**Rezoning Transportation Analysis**  
**Petition Number: Insert Zoning Petition #2021-258**  
*General Location Identifier: 04739101*

**Revision Log:**

Date	Description
04-28-22	First Review (PDM)
05-25-2022	Second Review (KP)

RZ.01

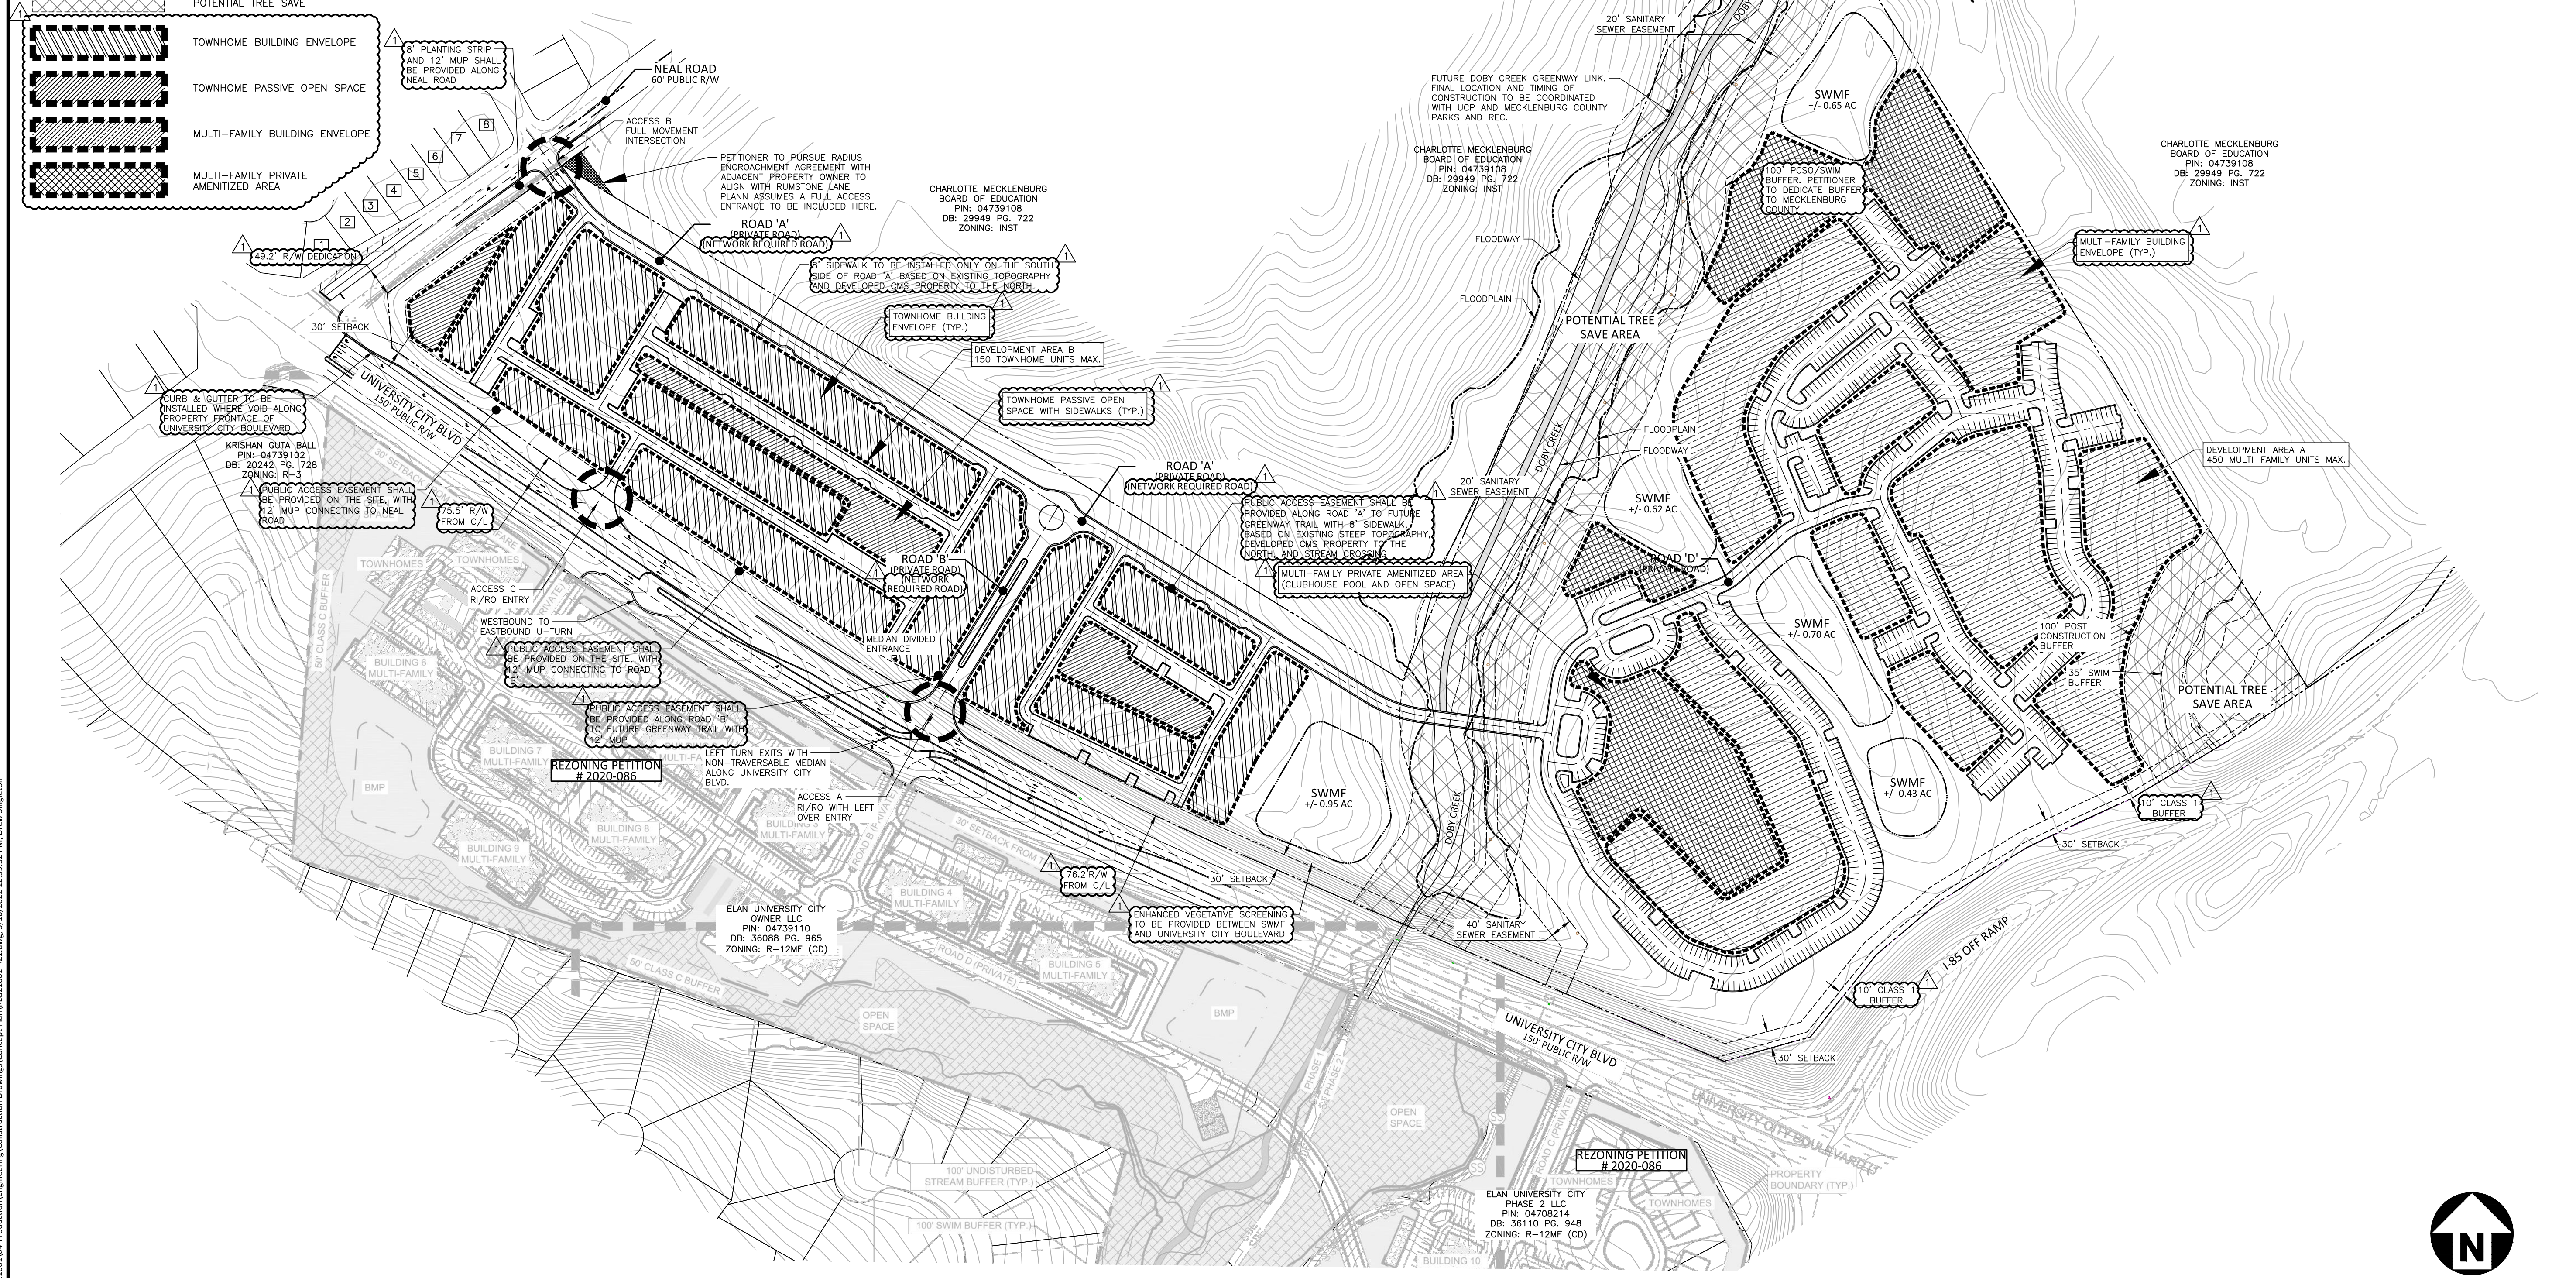
- 4. ~~Revise site plan to label and dimension the right of way on University City Boulevard from the road centerline.~~
- 5. Revise site plan and conditional notes to commit to installing a 12-foot multi-use path along the entire property frontage of University City Boulevard per Chapter 19 and 20 of the City Ordinance. The multi-use path should be located outside of the limits of the NCDOT controlled access/right-of-way and should be located within a sidewalk utility easement. The multi-use path also meets the requirements outlined in the council adopted Charlotte WALKS and Charlotte BIKES policies. A transition will need to be provided at the intersection of Neal Road to transition bicyclist from the multi-use path to the existing on-street bike lane facilities west of Neal Road.

**Clarifying comment from 05.25.22:** CDOT is having ongoing discussions with the petitioner to determine where the required bike facilities will be installed to meet the intent of this requirement.

- 6. CDOT **RECOMMENDS** revising the site plan and conditional notes to commit to installing a traffic signal at the intersection of University City Boulevard and proposed Entry #1 with a two-stage z-crossing for pedestrians. The traffic signal is recommended by CDOT, NCDOT and Mecklenburg County to provide a safe pedestrian crossing across University City Boulevard. In addition to general vehicular and pedestrian traffic, pedestrian traffic from the proposed Doby Creek Greenway will use this intersection to cross University City Boulevard.

- 8. **Outstanding comment from 04.28.22:** Revise conditional note C.2 to reflect that any driveway adjustment must be approved by CDOT and NCDOT.
  - 2. The Site will be served by internal private streets, drives and alleys. Minor adjustments to the locations of the internal private streets, drives and alleys ~~shall~~ be allowed during the construction permitting process.

- 10. **Outstanding comment from 04.28.22:** Revise site plan and conditional note(s) to provide the typical sections for all internal private roads. CDOT recommends using the location residential median street

typical section with 8-foot sidewalks per CDLSM U-02. Sidewalks will be required along all private streets. If roads will be built to private street standards specify the appropriate CLDSM typical section.

11. A site plan note(s) specifying dedication and fee simple conveyance of all rights-of-way to the City before the site's first building certificate of occupancy is issued as needed. CDOT requests rights-of-way set at 2' behind back of sidewalk where feasible.

**Clarifying comment from 05.25.22:** Include "Fee Simple" conveyance in Transportation note 13.
